DeLUCA-HOFFMAN ASSOCIATES, INC.
CONSULTING ENGINEERS

MEMORANDUM

DATE: August 30, 2012

SUBJECT: Canal Plaza Hotel, Site Plan Review

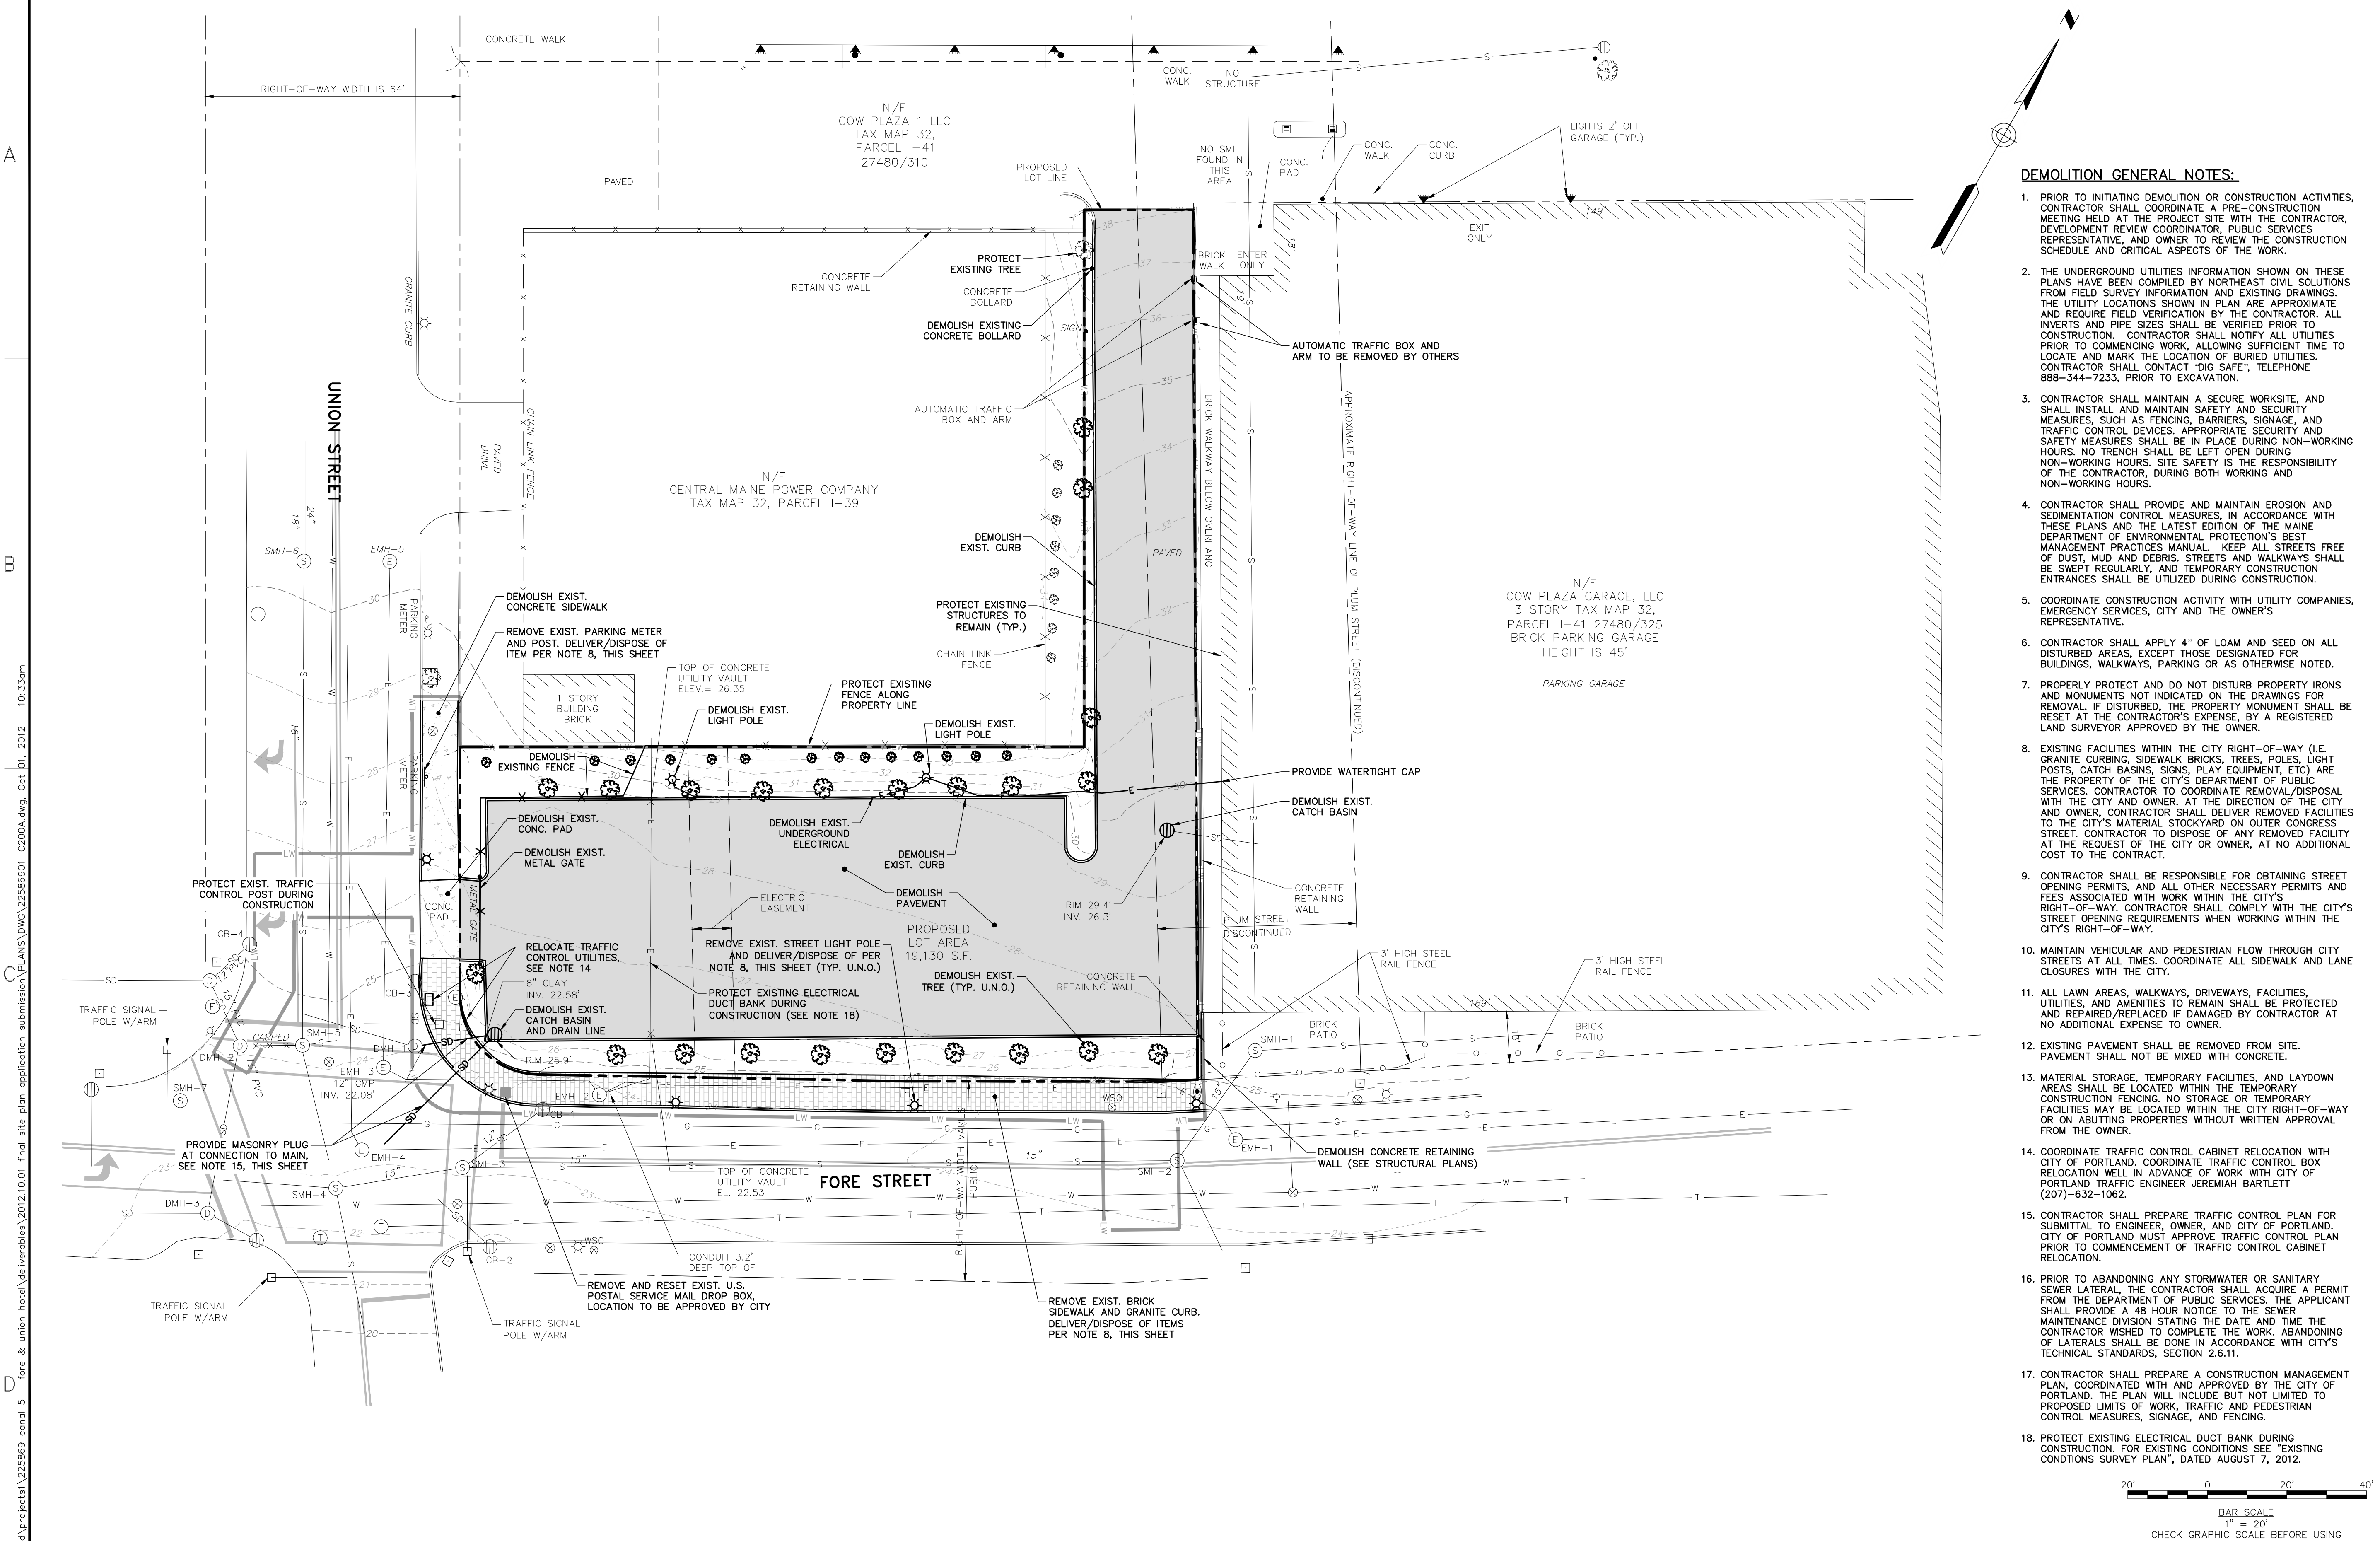
Sheet C-200 Demolition Plan:

1. It may be beneficial to include the anticipated work limits on the drawings, including work limits out into the City right of way.
2. It may be beneficial to add a note that all work to be completed in the City right of way be done in accordance with the City's street opening requirements.
3. The engineer should comment on any need for temporary interruptions of existing utilities services anticipated as part of the construction work.

C-201

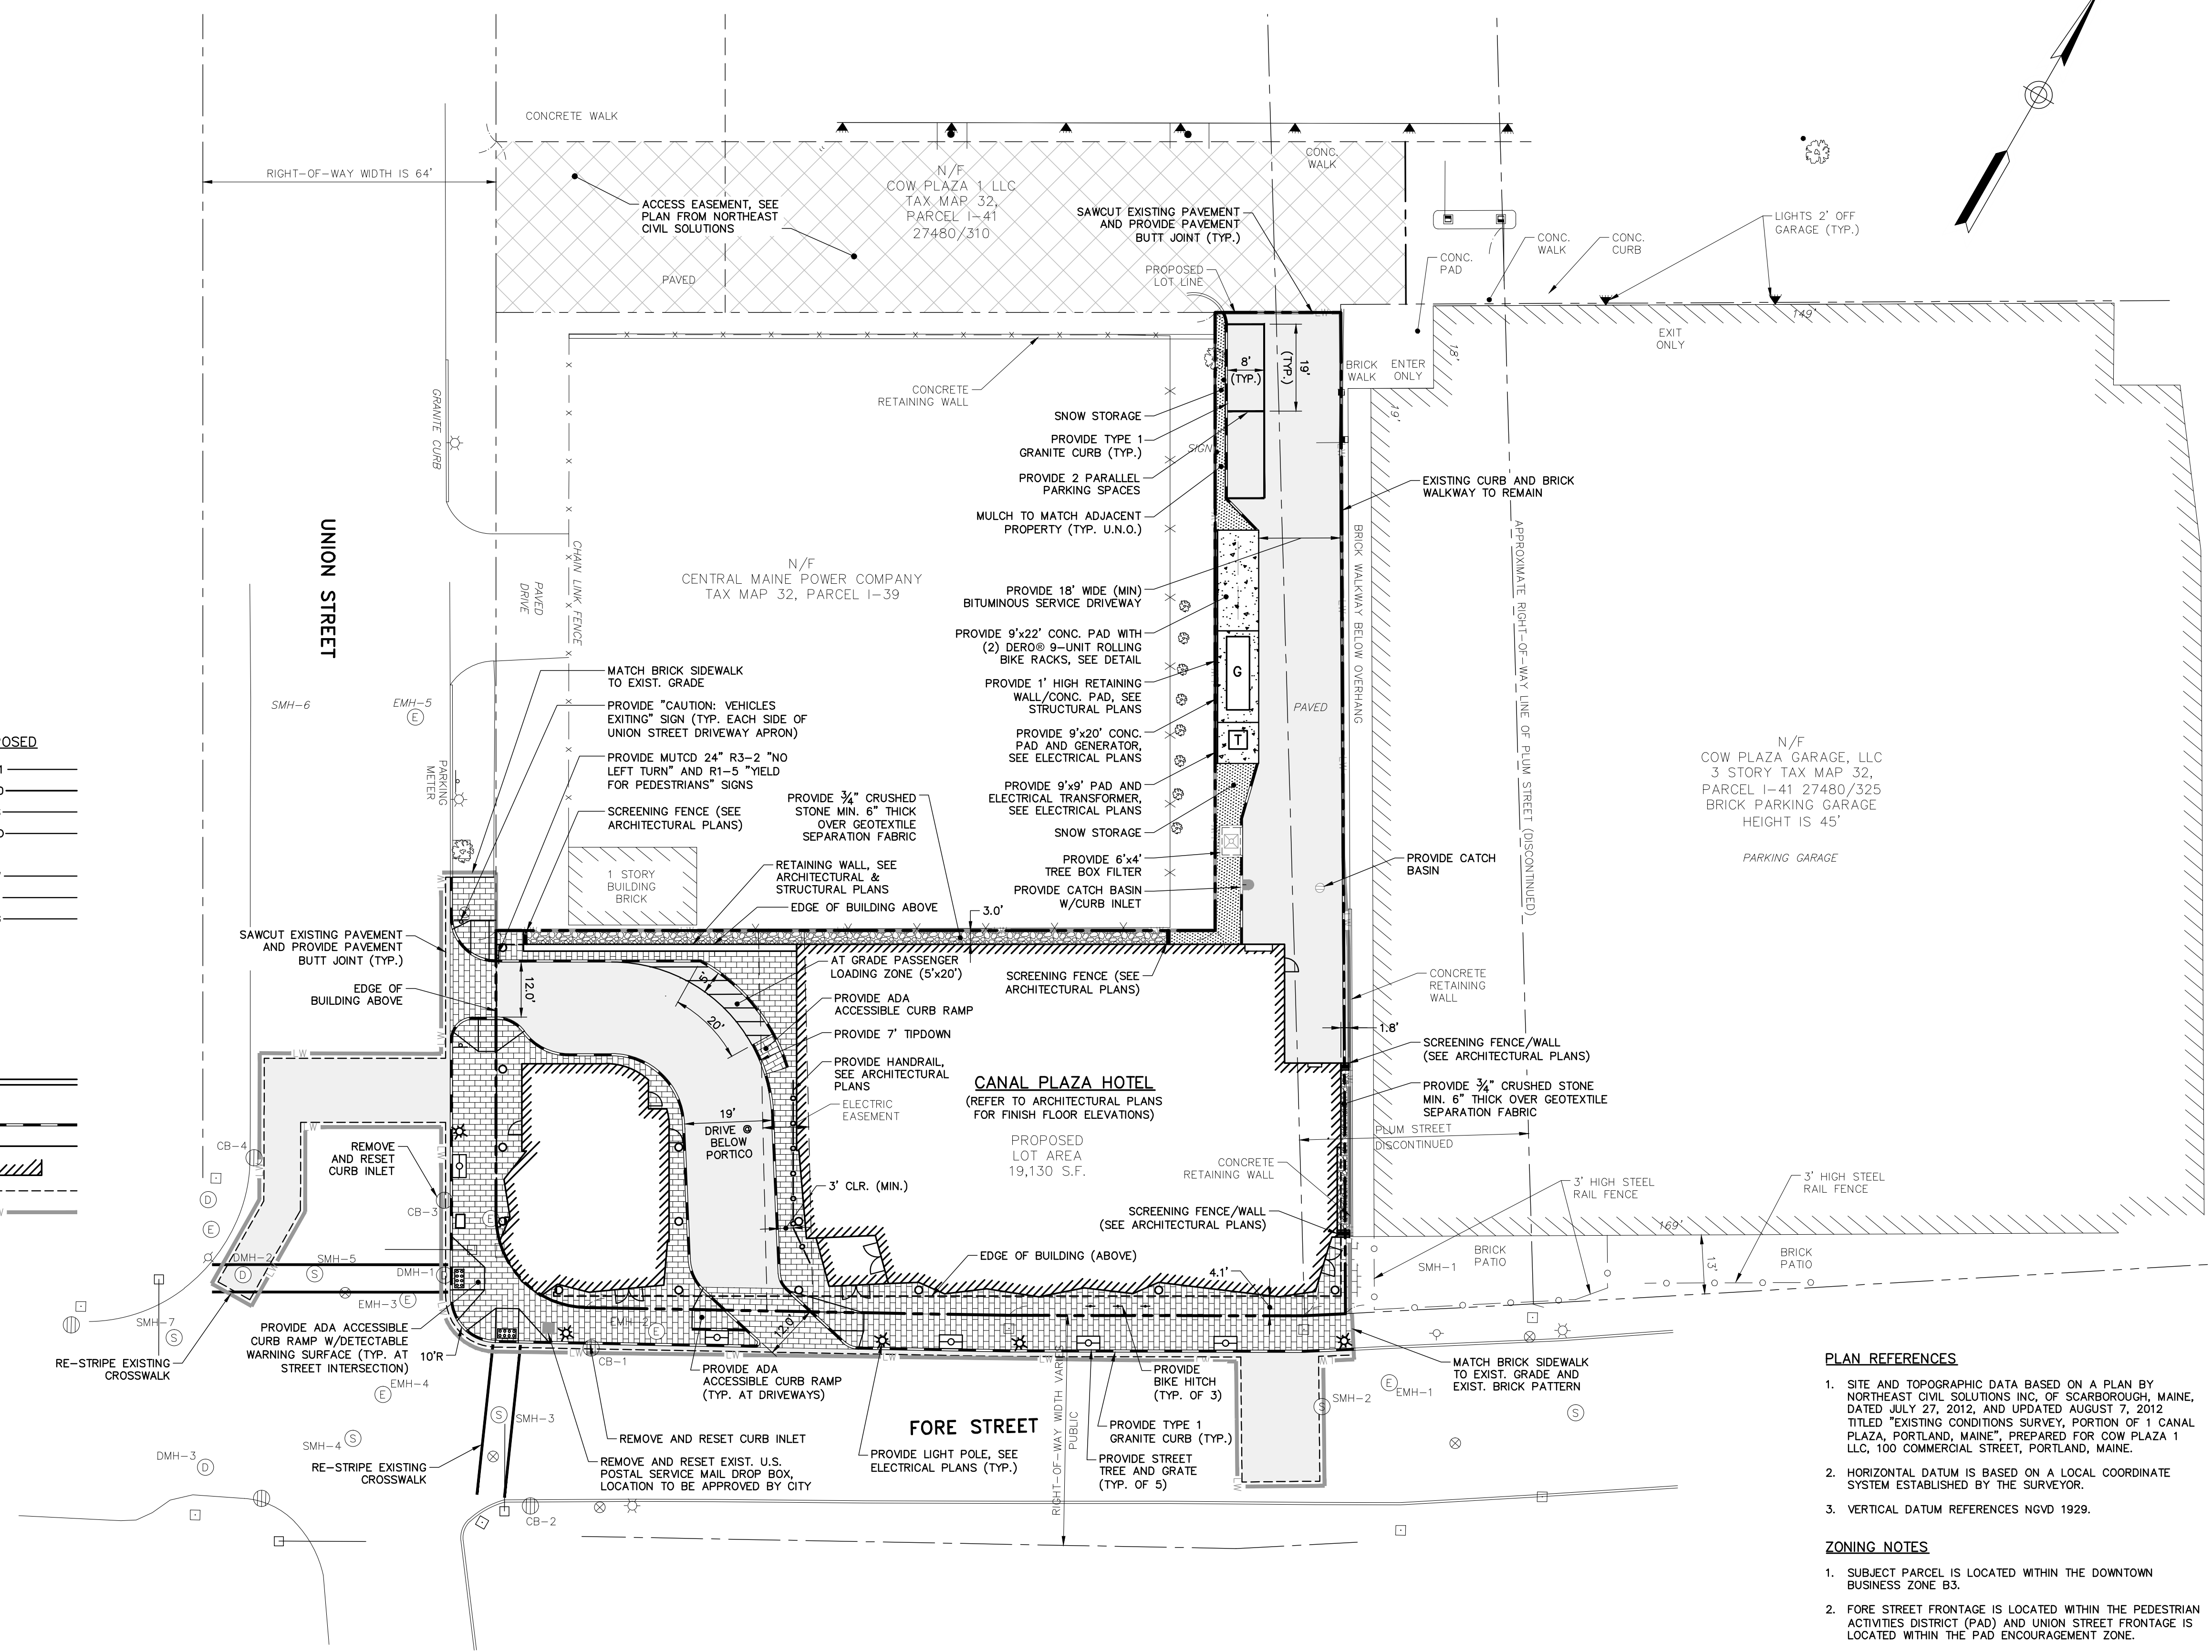
Sheet C-201 Site Plan:

1. The plan appears to indicate a transformer pad to the north side of the building within a 6' wide landscaped area. Typically pad mount transformers are no less than 7'x7' in dimension up to 9'x9' in dimension, so the engineer should review.
2. Some detail as to the retaining wall on the east side of the property including its constructability with respect to the building wall foundation should be reviewed. Drainage behind the wall may be particularly important.
3. We will reserve comments to the City Staff with respect to sidewalk configuration width, etc. along Fore Street particularly as it relates to the sidewalk system further east of the site which is broader in dimension.
4. The placement of ADA surfaces at the ramps at each driveway might be considered but may also not necessarily be required by Code. Applicant's engineer should confirm.

5. Applicant's engineer should confirm crosswalk material options at each driveway. Recommend consideration of something more than pavement paint markings although City Staff may want to weigh in on those choices.
